DRB Project# 1002646 Subdivision Name Bridges Addition

APPLICATION NO. 03 DRB-00742	PROJECT NO. 1002646
PROJECT NAME BRIDGES ADDN. BL. 1	
EPC APPLICATION NO.	
APPLICANT / AGENT PRECISION SURVEYS, INC.	PHONE NO. 856-5700
ZONE ATLAS PAGE J-11	<i>Larry</i> LENOPE ...
<b>ONE STOP COMMENT FORM LOG</b>

**RE: REQUEST FOR PRELIMINARY/FINAL PLAT APPROVAL  
LOT 1-A, BRIDGES ADDITION  
ZONE ATLAS J-11-Z**

Plat of
 Lots 1-A-1 & 1-A-2, Block One of
Bridges Addition
 Albuquerque, Bernalillo County, New Mexico
 April 2003

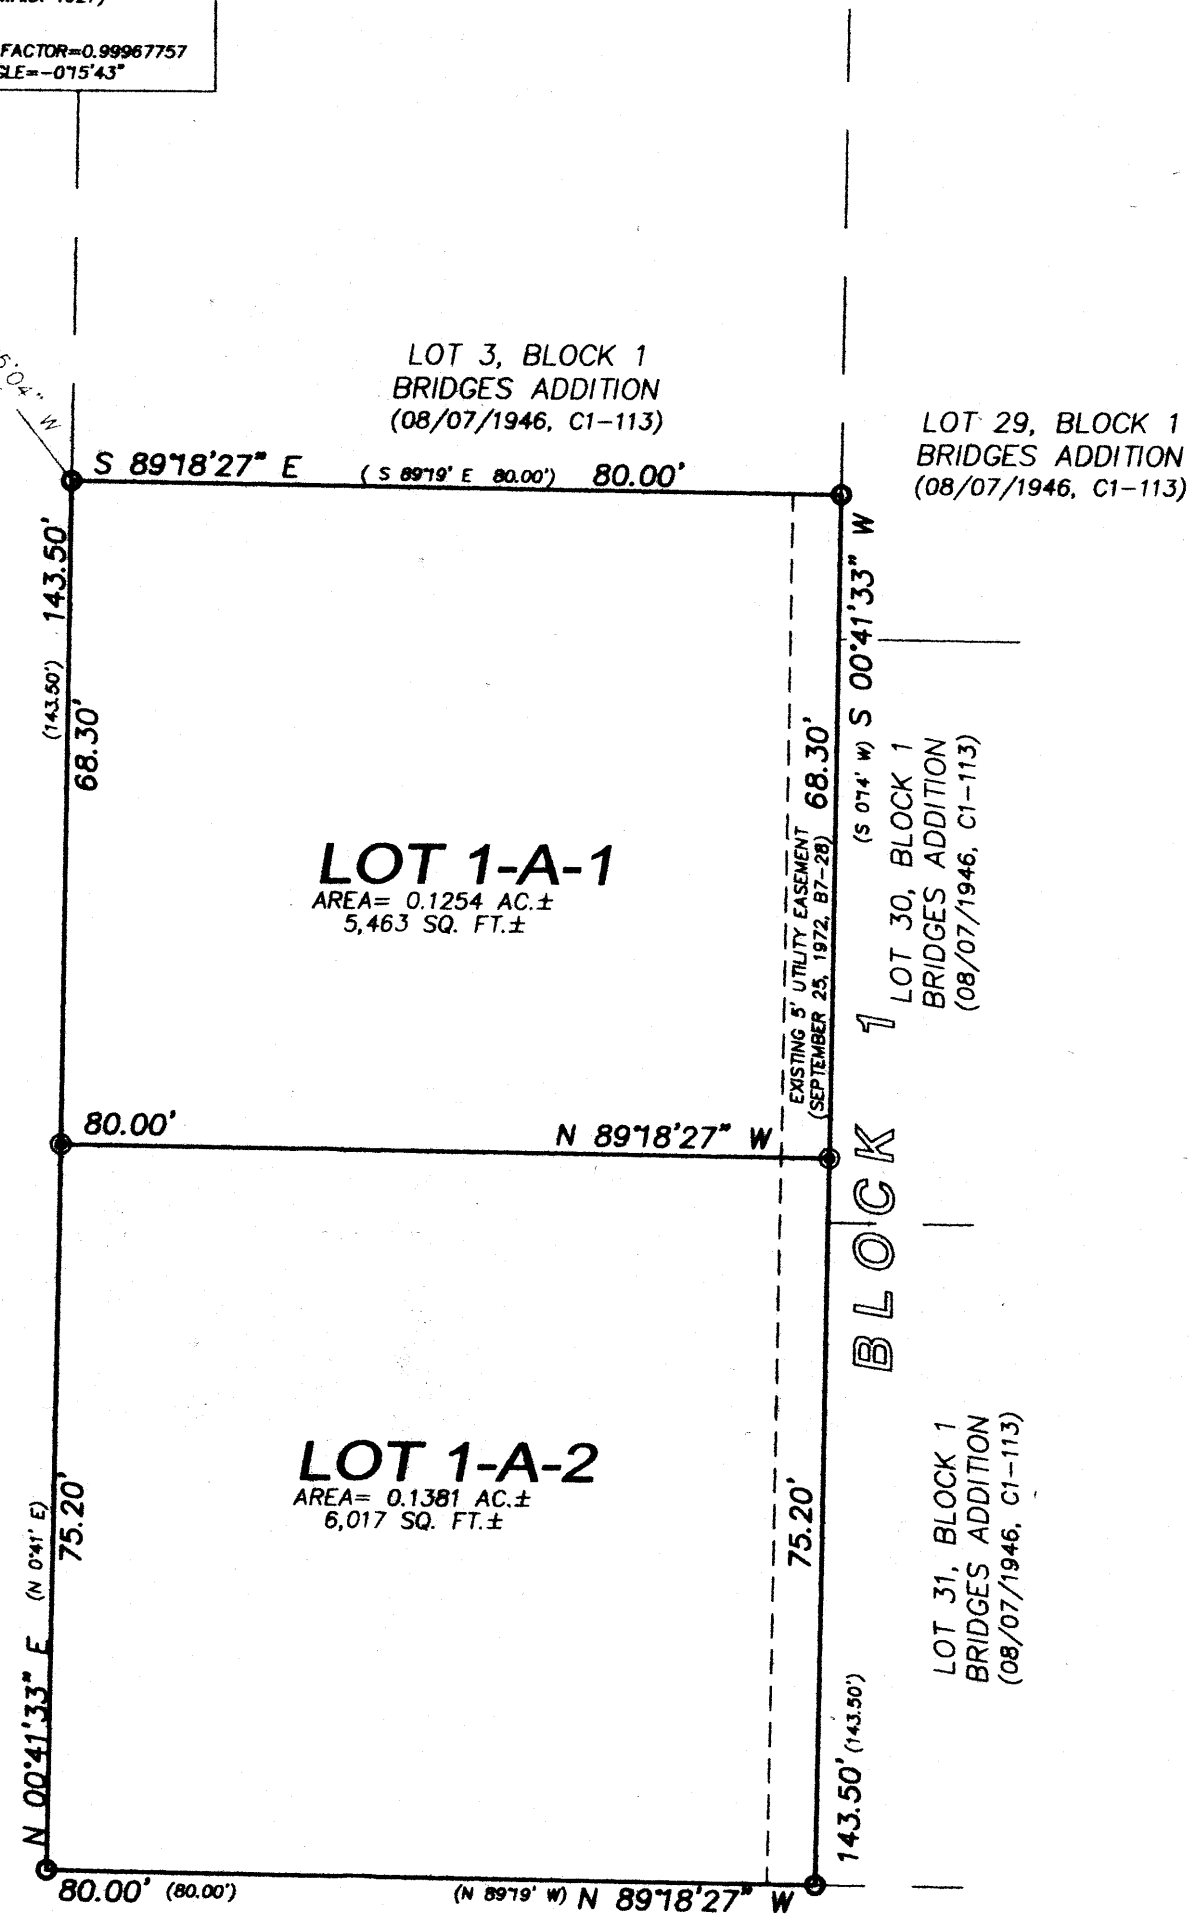
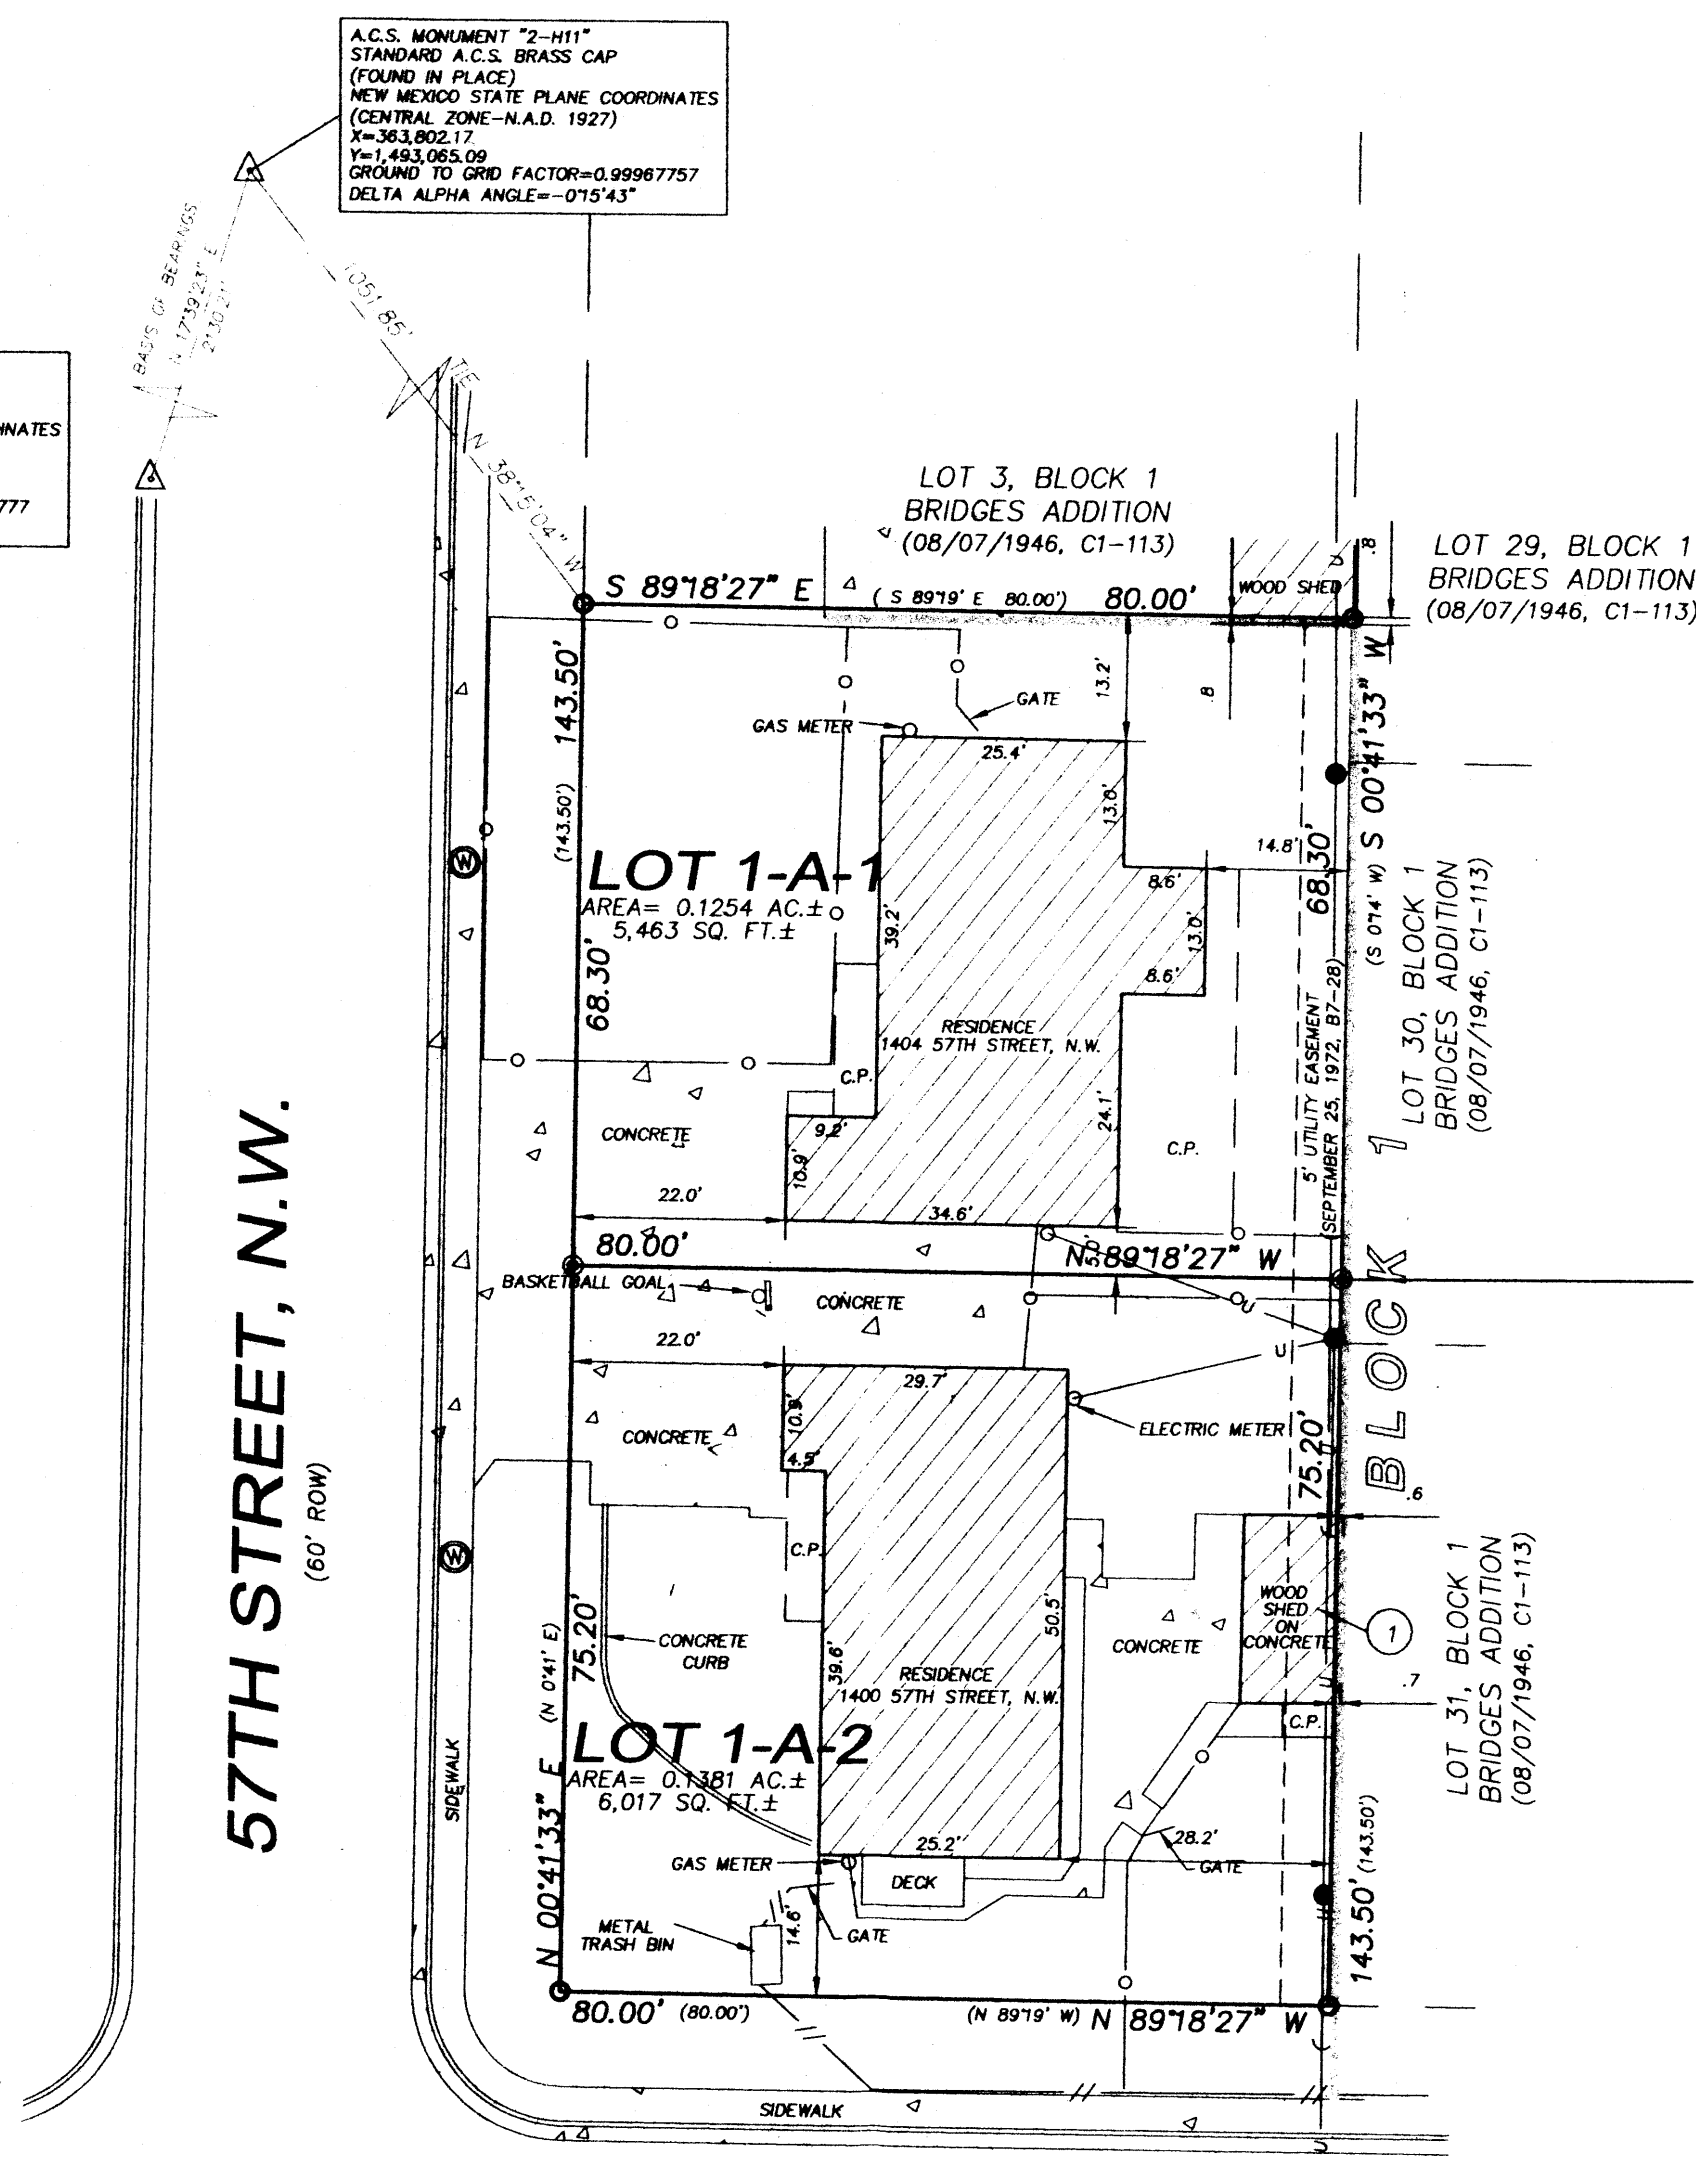
TRANSPORTATION DEV (505) 924-3990		
PLANS DISAPPROVED <i>NO</i>	DATE 5-08-03	DATE
PLANS APPROVED <i>NO</i>	DATE 5-14-03	DATE
Need to Dedicate COMMENTS: @ A 10' corner RADIUS.

TRANSPORTATION DEV (505) 924-3990		
PLANS DISAPPROVED	DATE 5-05-03	DATE
PLANS APPROVED	DATE	DATE
COMMENTS: Abundant no. of... @ 2 10' CORNER RADIUS.
